THE HILLS SHIRE COUNCIL

27 February 2015

**COUNCIL SUBMISSION - EXHIBITION OF MODIFICATION REQUEST FOR SENIORS
HOUSING DEVELOPMENT - NOS. 34 - 36 MEMORIAL AVENUE, KELLYVILLE (MP
09_0180 MOD 6)**

HYDRAULIC SERVICES
SITE PLAN - STORMWATER
DRAINAGE

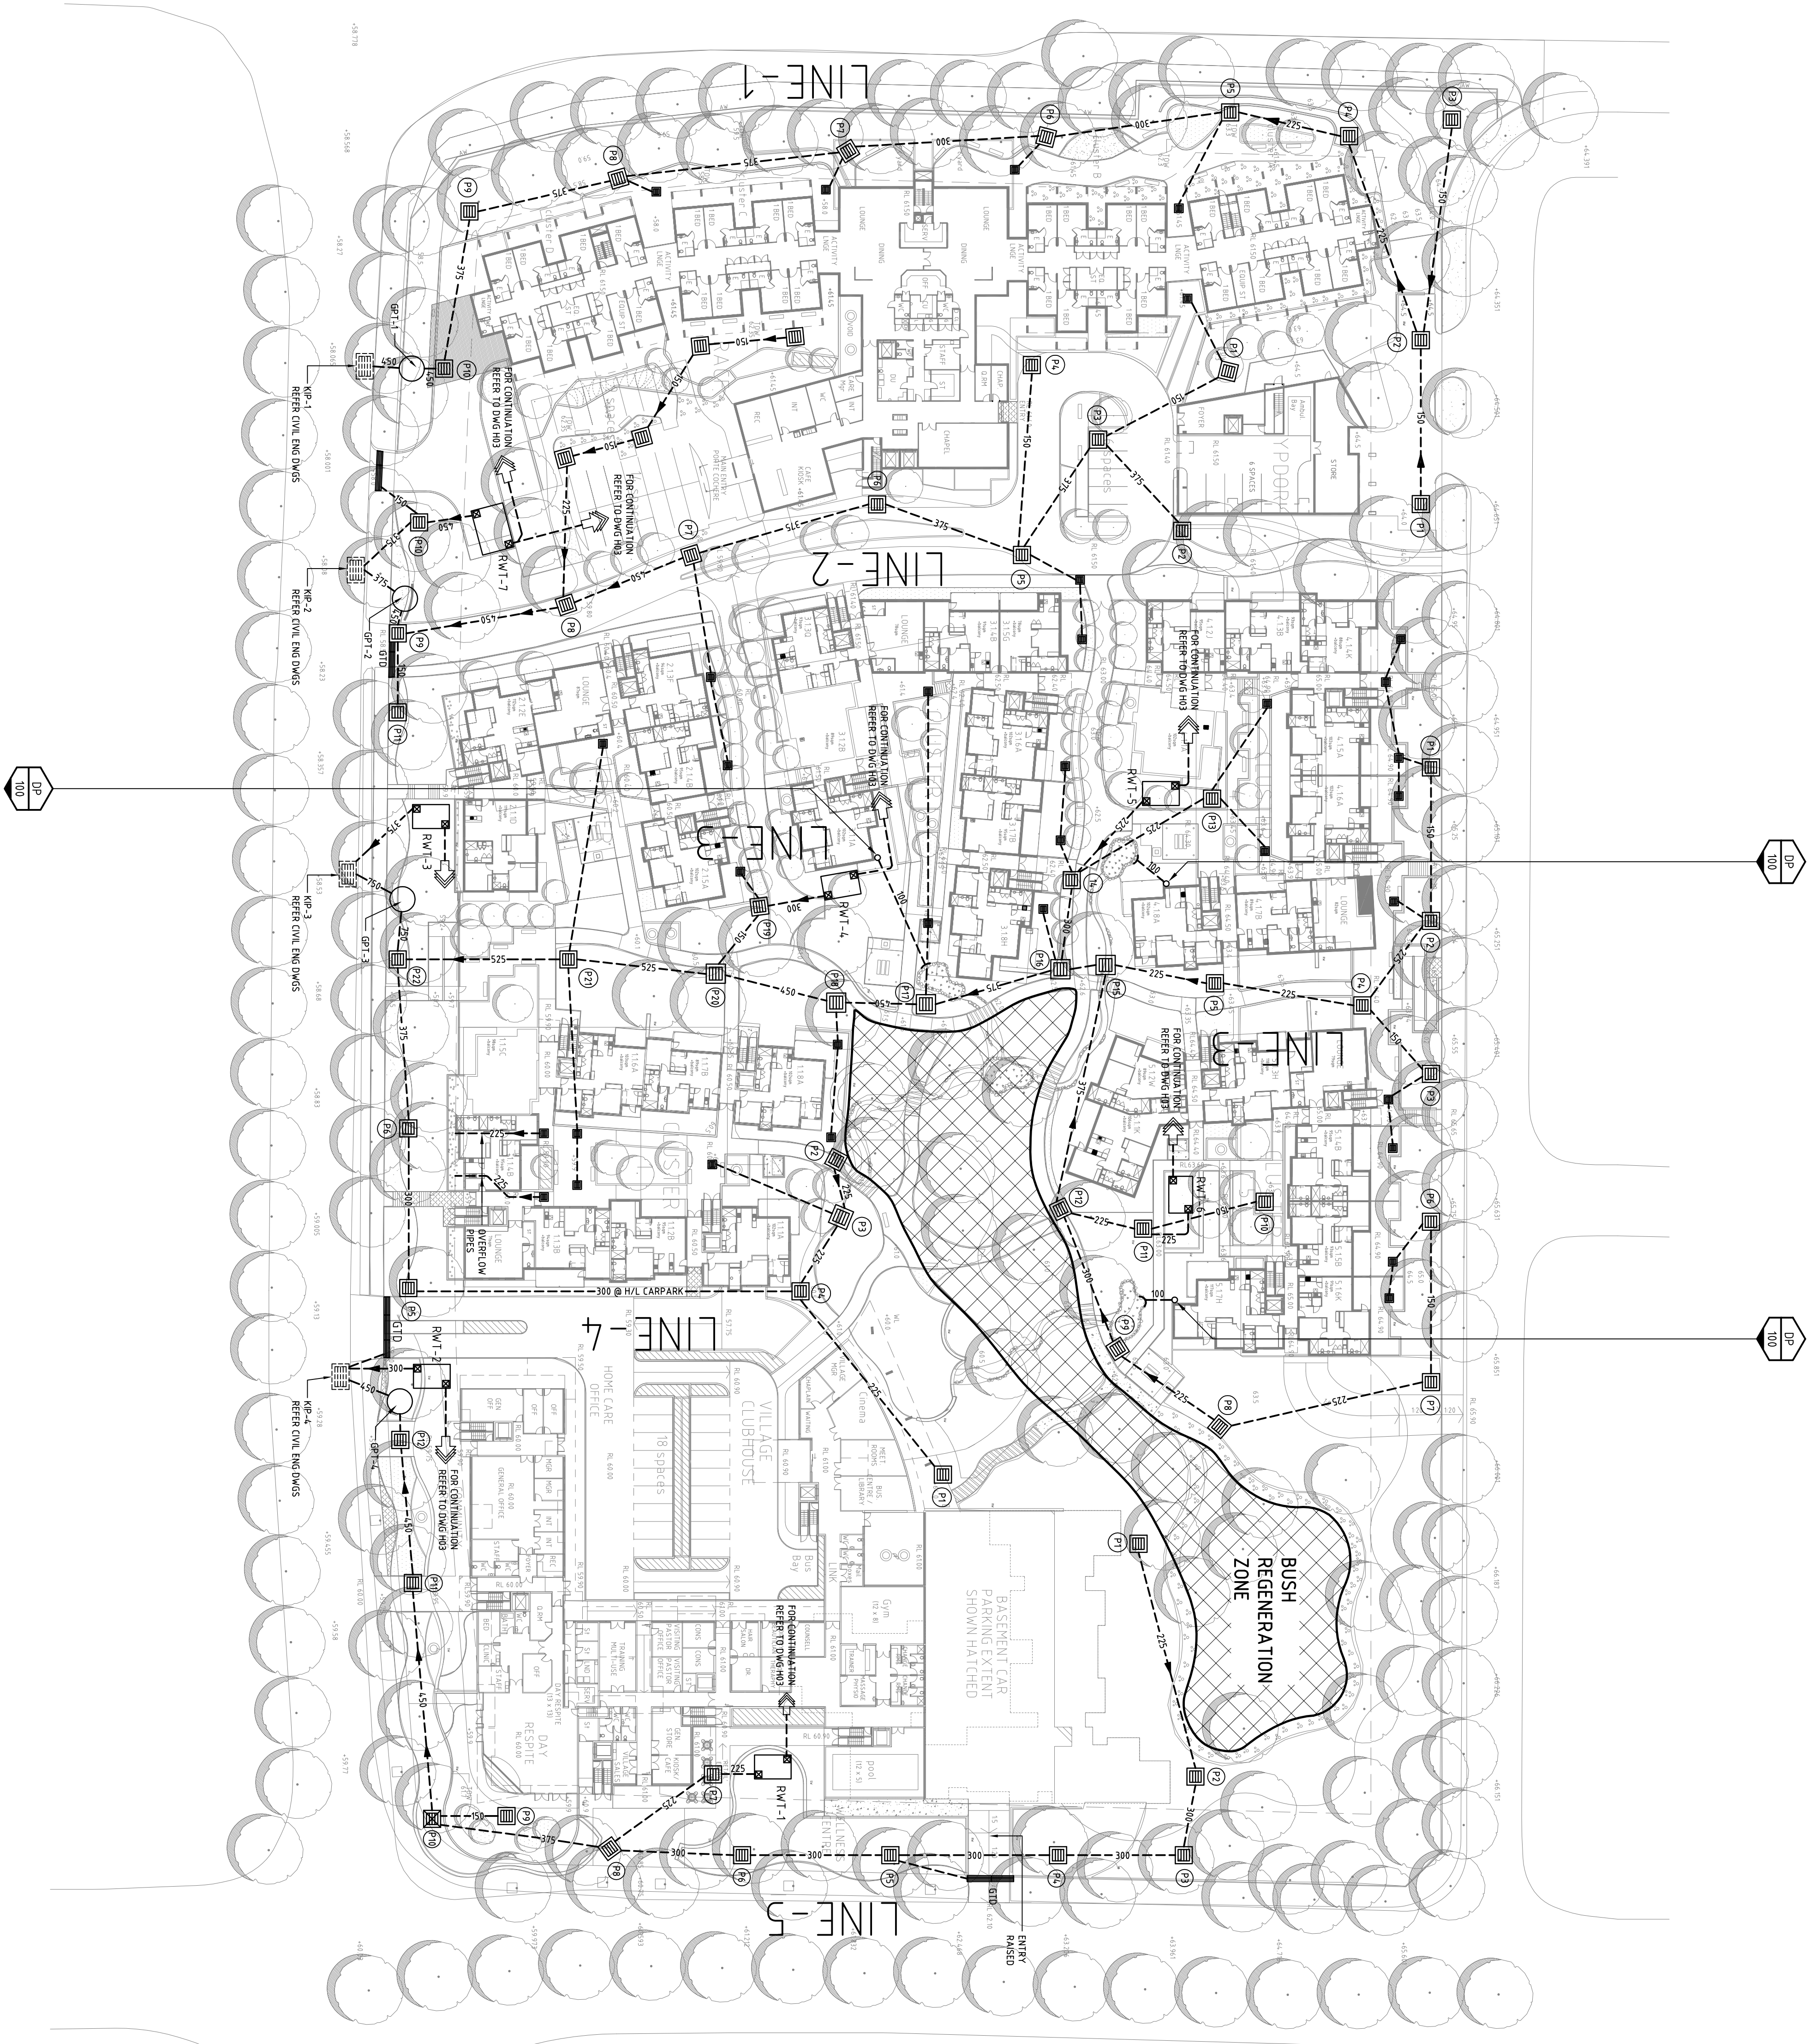
1. The development as modified is recognised as a valuable community asset providing housing for seniors as well as associated services.
2. The proposed bulk, scale and design is consistent with the envisaged character of the zone.
3. The depth of car parking spaces should be defined on the plans to demonstrate compliance with the provisions of Australian Standards 2890.1.
4. Consideration should be given to requesting a Model for Urban Stormwater Improvement Conceptualisation (MUSIC) model to demonstrate the effectiveness of what is proposed with respect to the pollutant loads generated by the development.
